CITY OF PORTLAND

January 2, 2001

RE: 305 Palmer Avenue – 353-E-012 – R-2 zone

305 Palmer Avenue
Portland, Maine

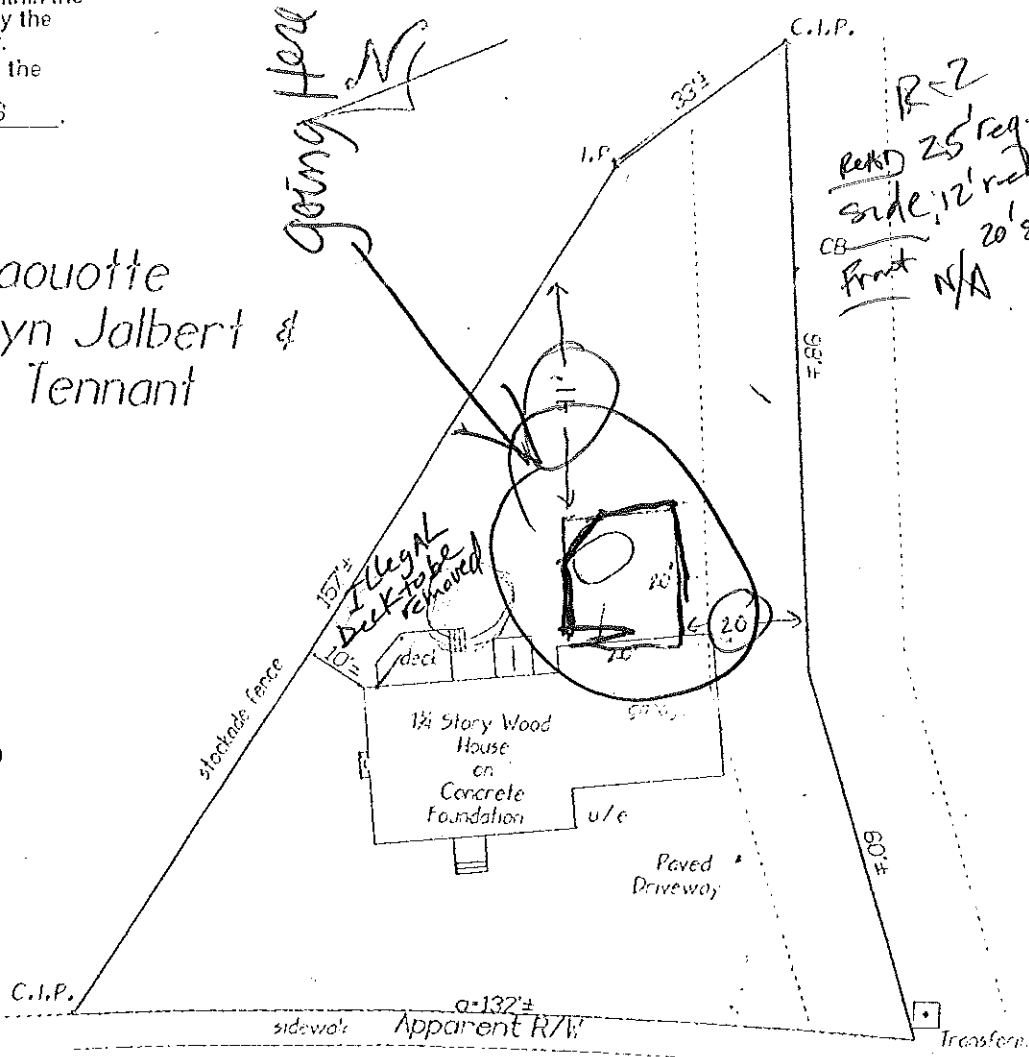
I am in receipt of your building permit to erect a deck with a hot tub. Your permit is being denied because you are not meeting the required setbacks. Your property is located in an R-2 residential zone which requires a twelve (12) foot side yard setback (section 14-80(4)). Your submitted plans show only six (6) inches to the side yard. The R-2 zone also requires a twenty-five (25) foot rear setback. Your plans do not give a specific rear setback, but if your plans are to any type of scale, you are much closer than the required 25 foot. As stated your permit is denied because you can not meet the required setbacks.

If you wish to relocate your deck so that you would meet the requirements of the R-2 zone, I would be glad to review any revised plans. Please call if you have any other questions regarding this matter.
